Arun District Council
Arun Civic Centre
Maltravers Road
Littlehampton
West Sussex BN17 5LF
Planning & Building Control General Enquiries
Tel: (01903) 737756 Fax: (01903) 730442
Dx: 57406 Littlehampton
Minicom: 01903 732765
e-mail: planning@arun.gov.uk
website: www.arun.gov.uk/planning

Application No: FG/52/22/HH
Site Address: 6 Beehive Lane Ferring BN12 5NL
Description of works: Erection of two storey front extension with front canopy, single storey side and rear extension and extension of loft to habitable use including the installation of 1 x side dormer.

Thank you for your internet representation made on 18th April 2022 which has been recorded as an objection with the comments as follows:

Drawing
Proposed Elevations

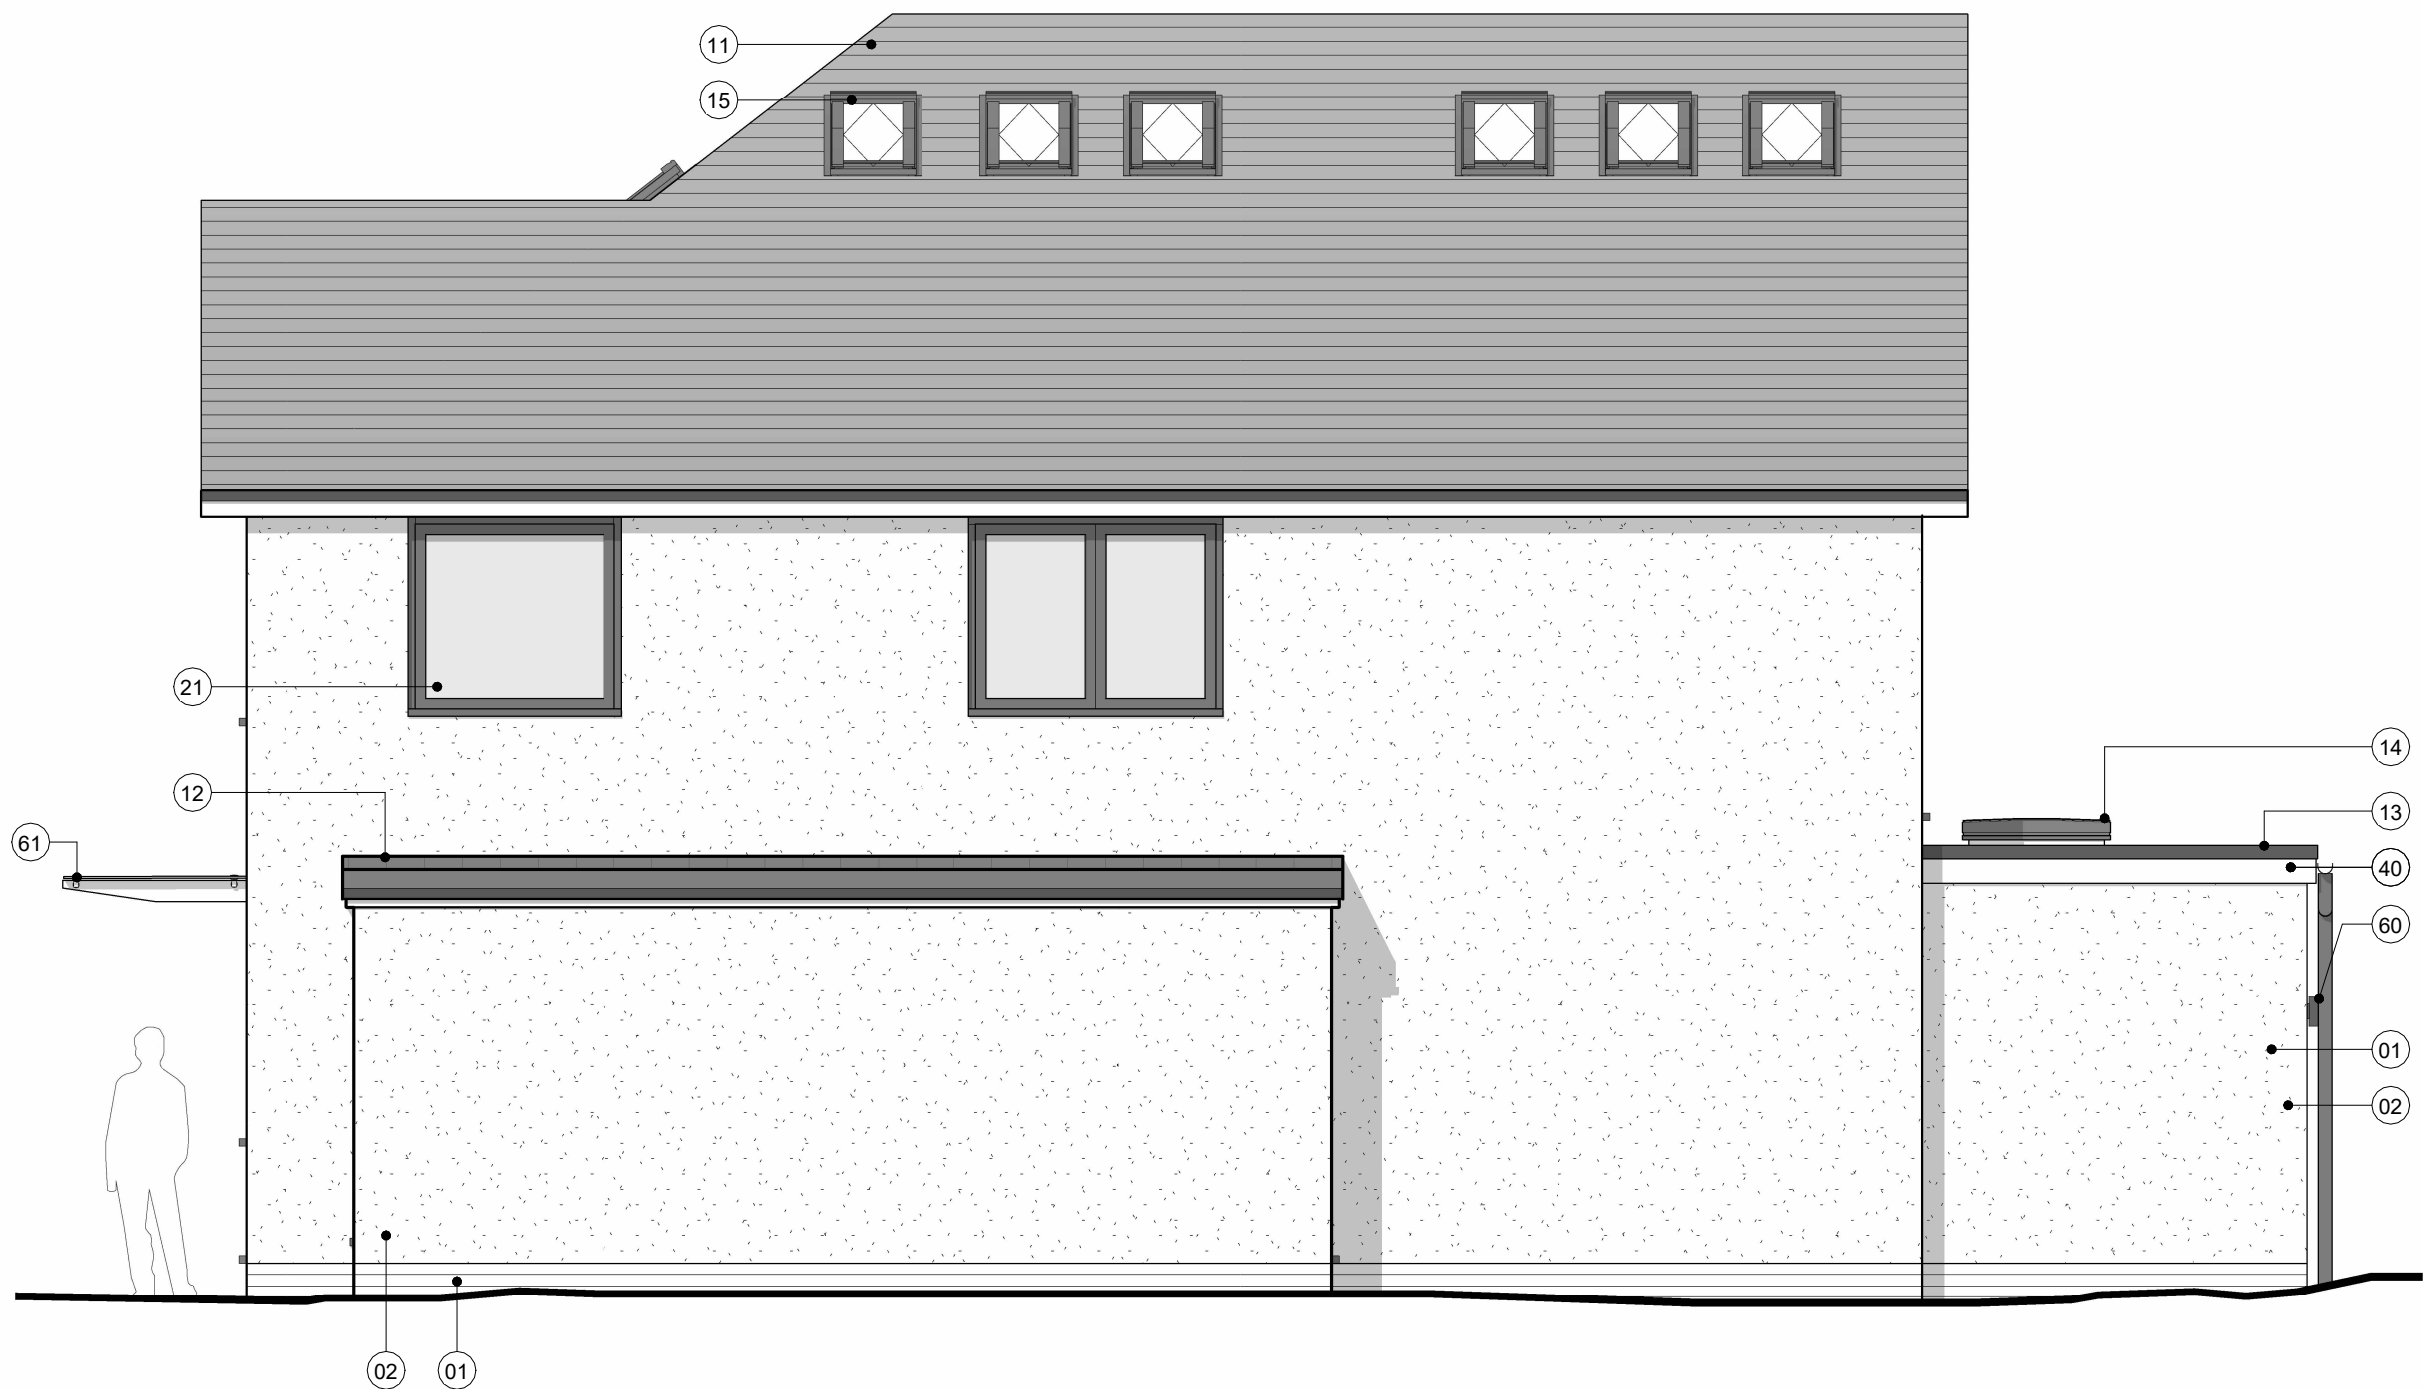
In particular I object to the proposed enlargement of the second floor by the addition of a very large side dormer and the southern extension of this floor to form a gable.

In both instances, the overbearing impact of the dormer and the gable on the adjoining bungalows and chalets, in particular to the east and south, is totally unacceptable. The proposed new large windows in both the dormer and the gable will also seriously reduce the privacy of these properties.

The dormer is shown to be constructed straight off the existing external walls along the east and south elevations creating in effect a full three storey dwelling to these flanks. The resulting scale would be out of character with the rest of South Ferring and the Beehive Lane area in particular and would create a most unfortunate precedent in a village characterised largely by bungalows and chalets.

The other matter of concern would be the appearance of the excessive dormer when viewed from Beehive Lane, Chalet Road and Chalet Close, which quite frankly would be hideous. Dormers should be properly designed as subservient within a roofscape, not as a completely dominant feature as proposed here.

3 PROPOSED 2ND FLOOR
2002 Scale: 1 : 50

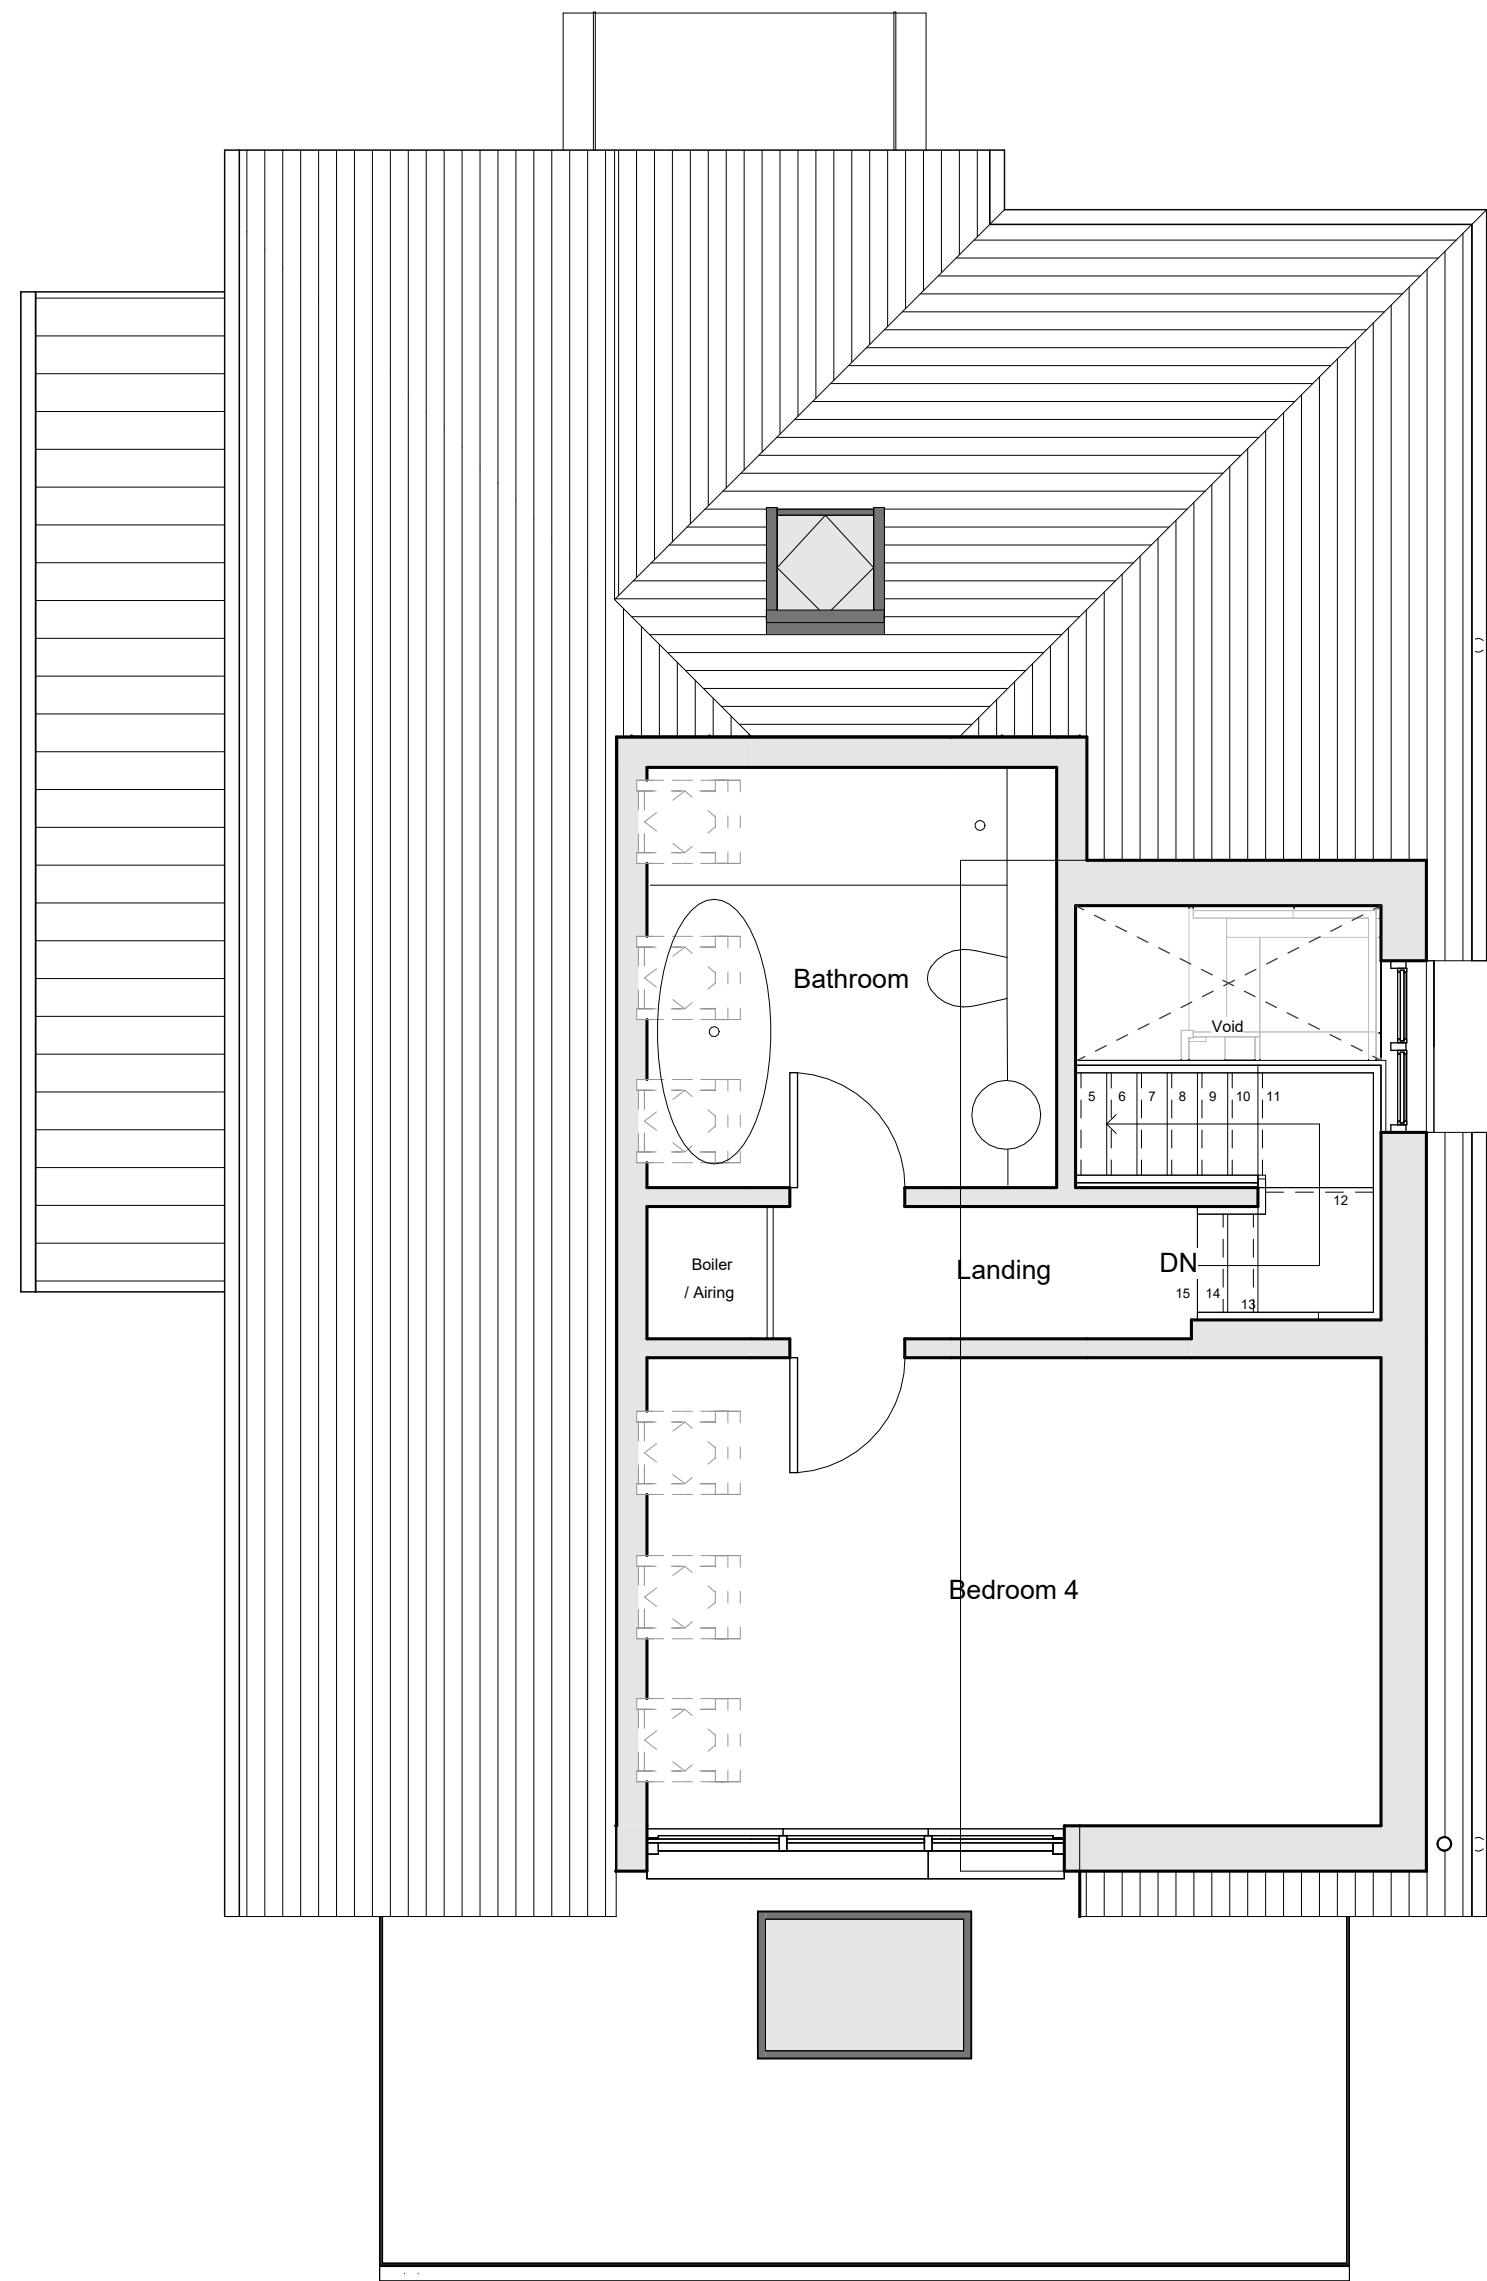
The proposed second floor needs to be totally reconsidered to take these comments into account including a significant reduction in the accommodation proposed on this floor.
